From: Matt Thayer <mthayer777@gmail.com>
To: Ethan Boxer-Macomber <ethan@anew-development.com>, Peter Bass <pbass@maine.rr.com>, Ethan Strimling <estrimling@portlandmaine.gov>, Belinda Ray <bsr@portlandmaine.gov>, Jeff Levine <JLEVINE@portlandmaine.gov>
CC: "Daniel T. Haley, Jr. CIC" <danielthaleyjr@gmail.com>, "Daniel T. Haley, Jr. CIC" <danielthaley@gmail.com>, Gary Marcisso <gmarcisso@yahoo.com>, Justina Marcisso <jmarcisso1@yahoo.com>, Eric Stark <eric.stark@maine.edu>, Margaret Hazlett <mhazlett@fandm.edu>
Date: 1/21/2016 6:17 PM
Subject: Quick Public Input - For Meeting - 65 Munjoy St

Our "quick" comments for tonight are as follows:

DRAWN BY
EAC
 SHEET TITLE
FIRST FLOOR & SITE

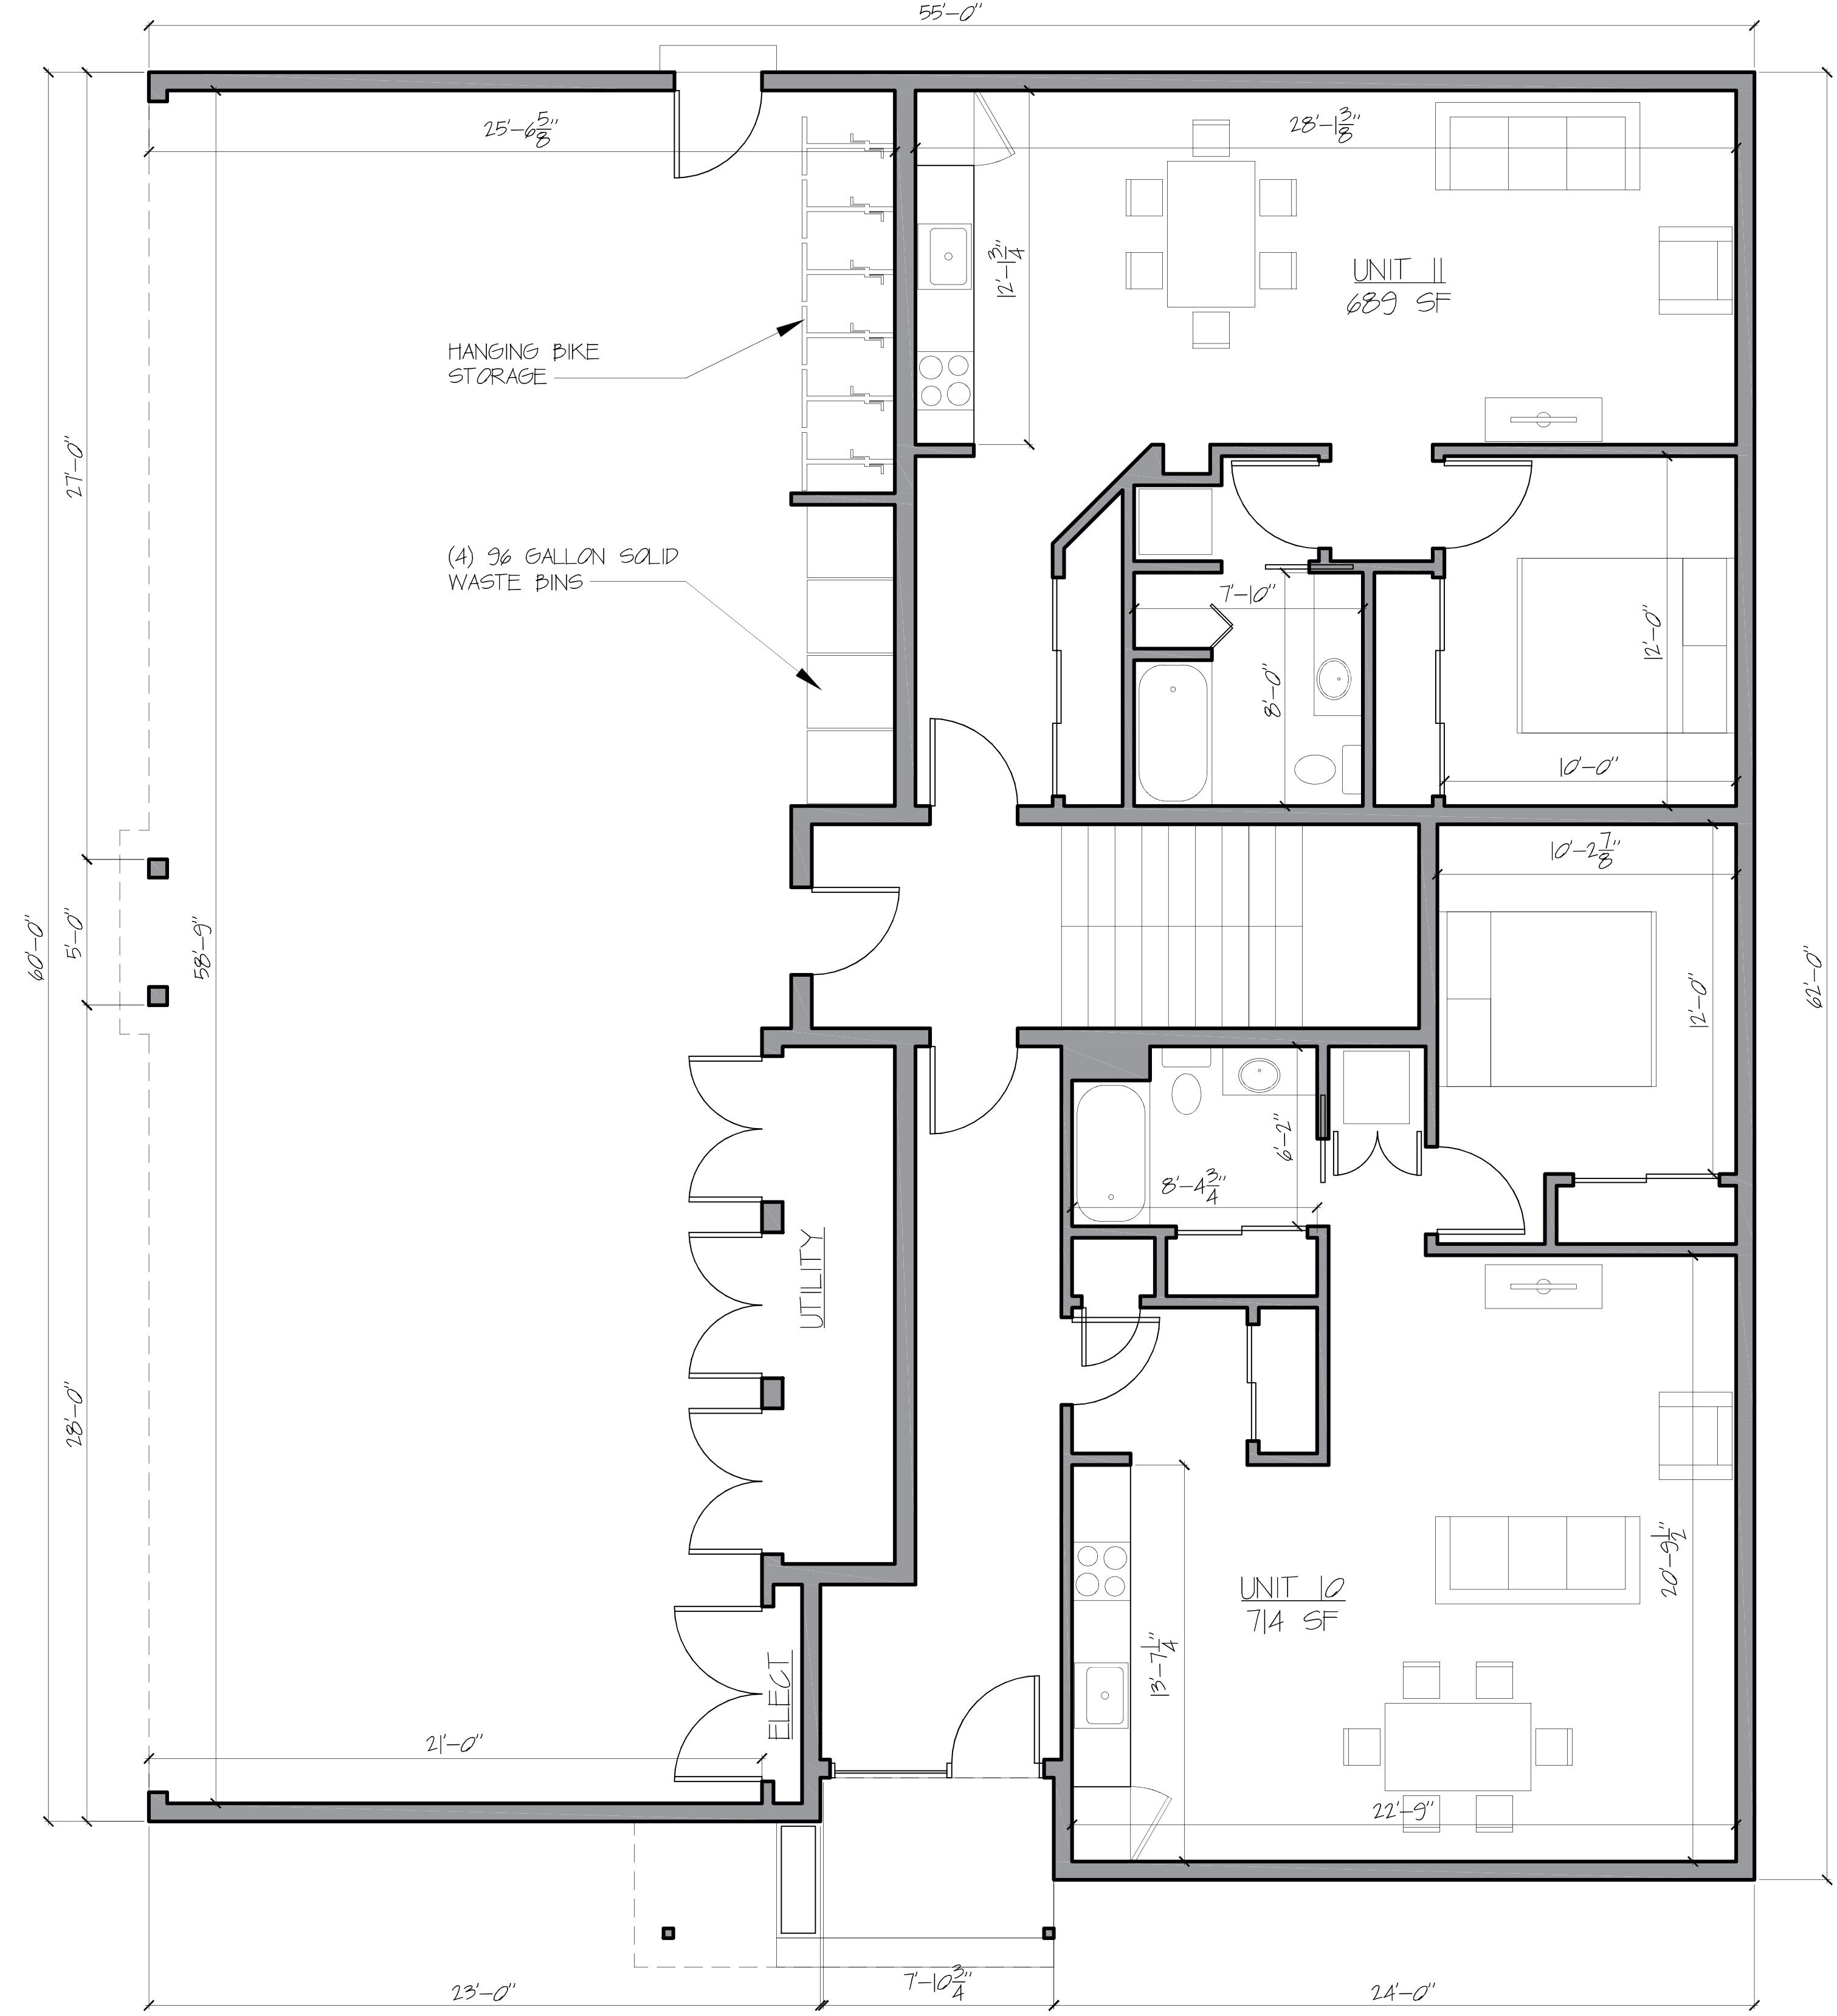
7. *A Design "Fail:" Your Proposed Building Sits Too Low to Ground, Some First Floor Windows Too Small.* You appear to have done your design to first and foremost accommodate cars in the house. The unfortunate result of letting the "tail" of cars and parking wag the "dog" of designing for occupants is that the building sits very low to the ground for an urban neighborhood, as can be seen by reference to other buildings in the neighborhood. In fact, it sits at sidewalk level, rather than above sidewalk level like other buildings in the neighborhood, which is apparently now creating concerns by your design team about privacy issues for 1st floor occupants. As a result, you seem to be shrinking window size for the first floor units, which will be cutting down on daylight for those folks, and making the fenestration seem very weird and stand out for those viewing the building from the outside, while passing by on Munjoy St., etc. We believe this building sits too low to the ground, and with windows being shrunk to create a sense of privacy, represents an architectural design "fail." There must be another way to design this building that works better for the occupants and the neighborhood.
